Tuesday, March 14, 2017 11:32:27 AM

PLAN  NORTH **1** TYPICAL FINISH PLAN  
1/4" = 1'-0"

**2** ENTRY DOOR JAMB - DETAIL  
1-1/2" = 1'-0"

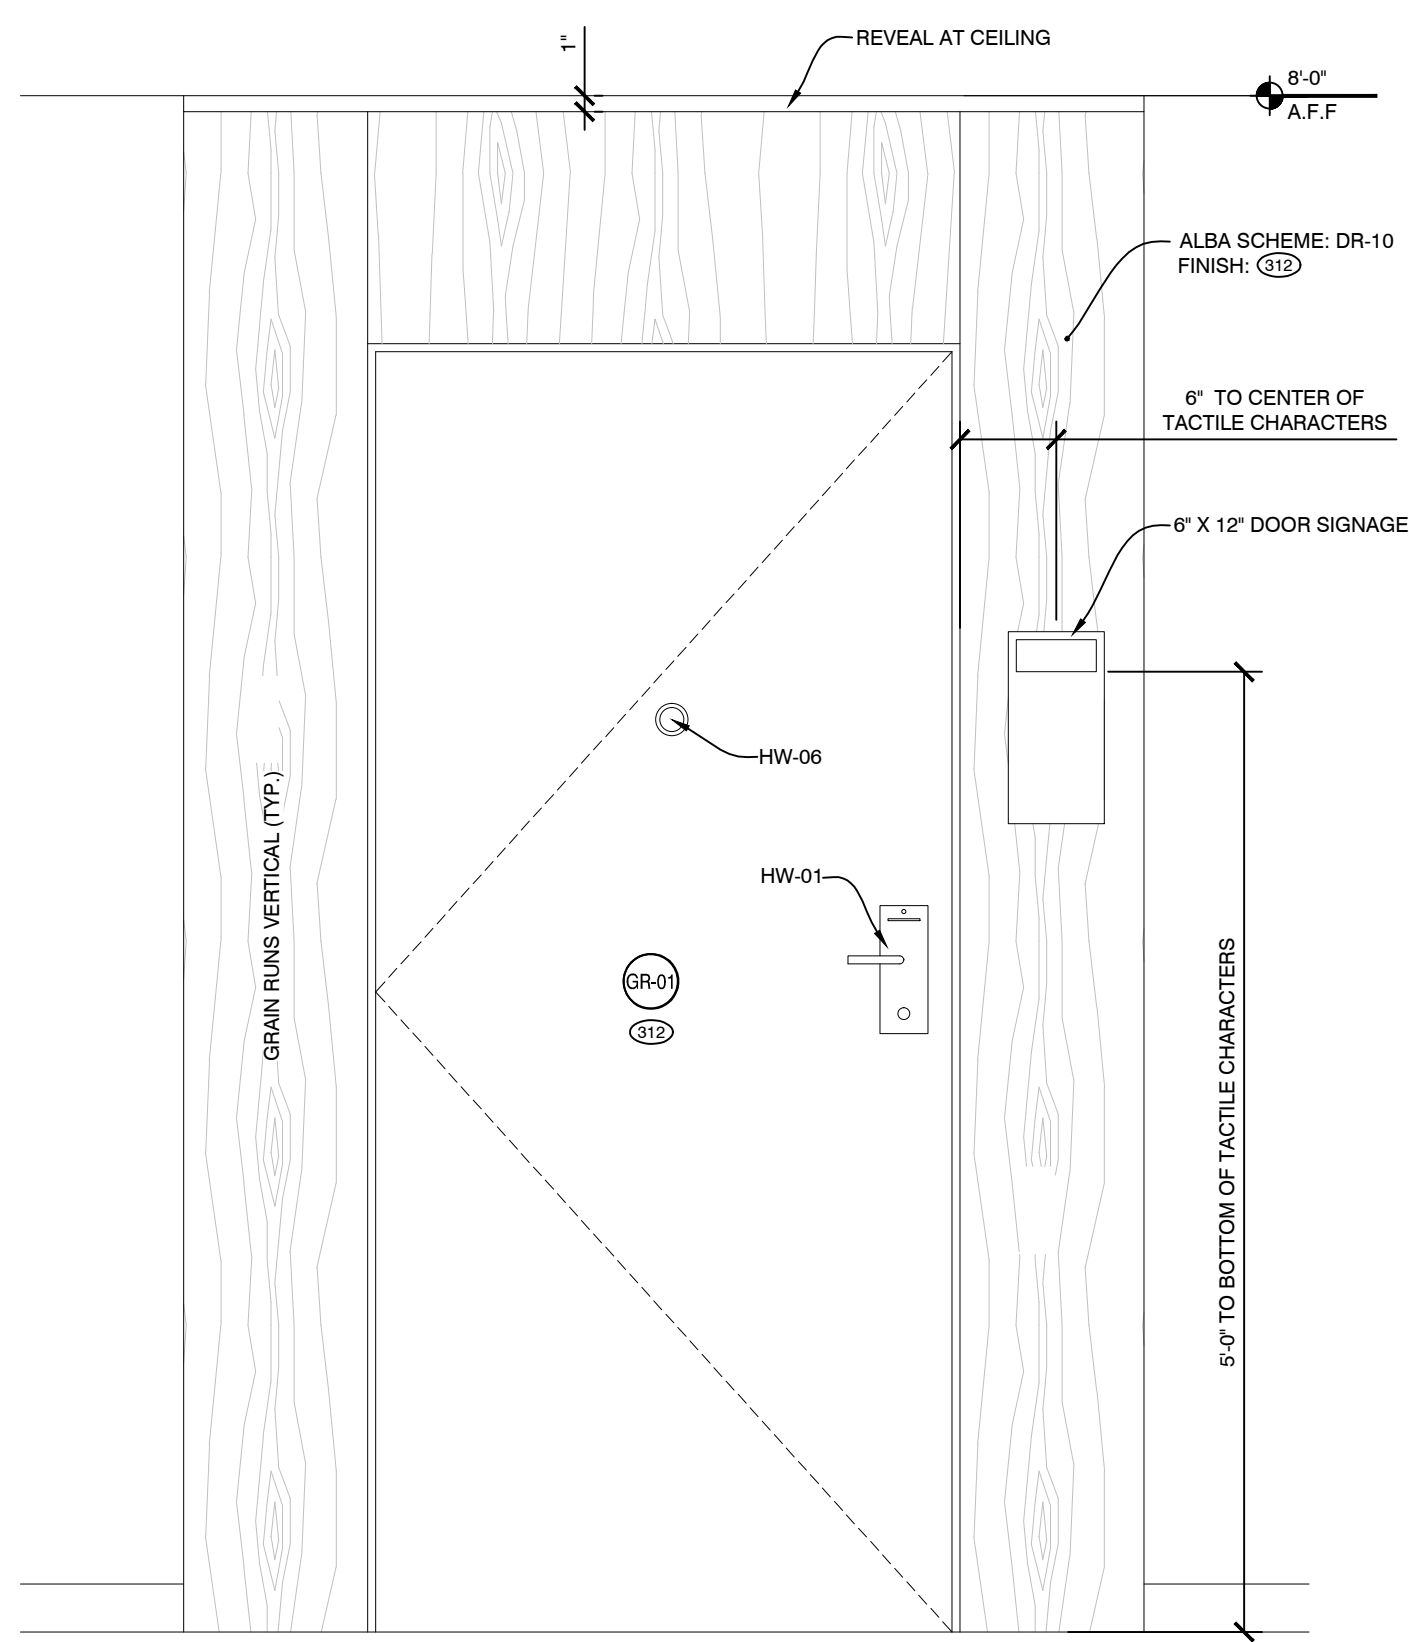
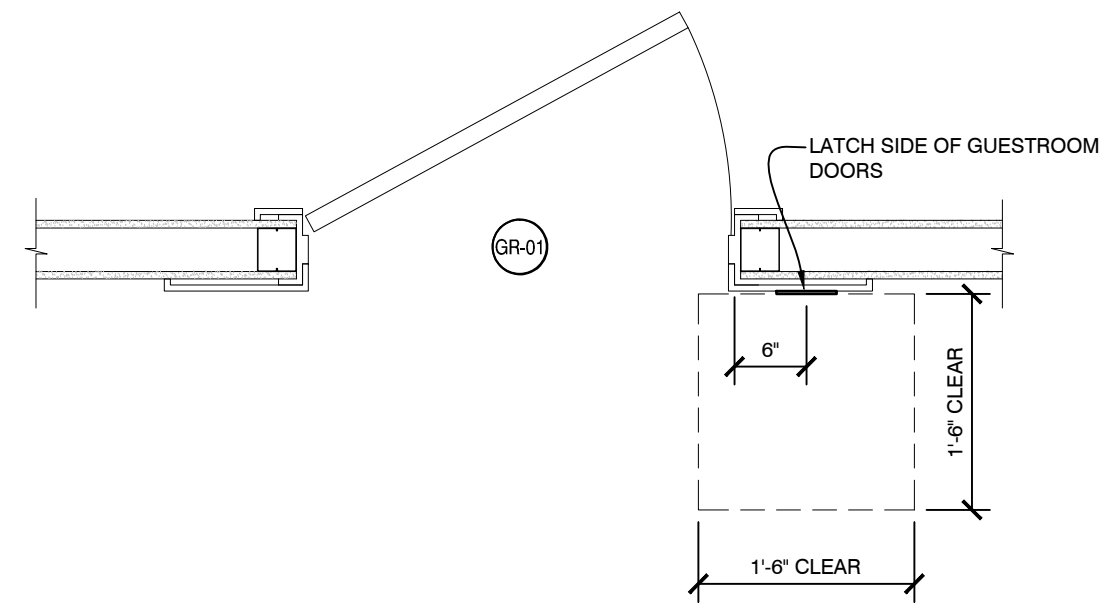
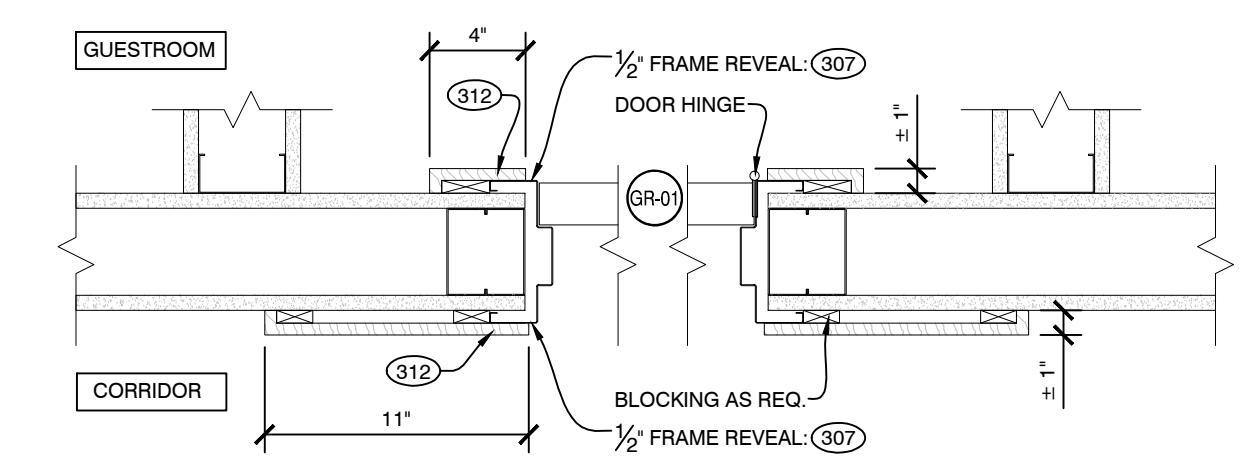
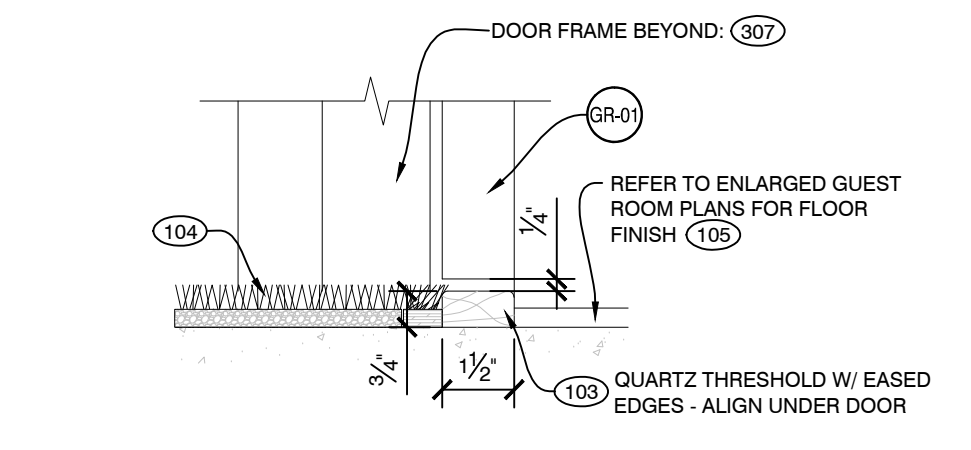
- 1 HARD WATER PROOF FINISH SURFACE AT HYDRATION STATION. SUBMIT TO MARRIOTT FOR REVIEW.
- 2 GLASS PANEL SURROUNDS AT ELEVATOR. SUBMIT TO MARRIOTT FOR REVIEW.
- 3 PROVIDE TWO ROOMS ON EACH GUESTROOM FLOOR THAT CAN BE KEYPED TOGETHER.
- 4 HPL DOOR SURROUNDS (AL-312) - SEE A6.04 FOR DETAILS. PANEL AT JAMB IS HELD BACK 1/2" FROM FRAME. PANEL AT HEADER IS HELD BACK 1" FROM CORRIDOR CEILING. DIMENSIONS TO BE VERIFIED IN FIELD PRIOR TO INSTALL.
- 5 HPL WALL PANEL (AL-312) TO FILL IN BETWEEN INDICATED DOOR SURROUNDS. REFER TO A7.0X FOR ELEVATIONS & DETAILS.
- 6 BASE BOARDS CAN BE PURCHASED THROUGH MARRIOTT AND IS IN THE ID SPEC MANUAL.
- 7 ANY GAP LEFT BETWEEN THE FLOORING MATERIAL AND THE GUESTROOM WALLS SHOULD BE NO MORE THAN A 1/2" SO THAT THE BASE WILL COMPLETELY COVER THIS GAP.
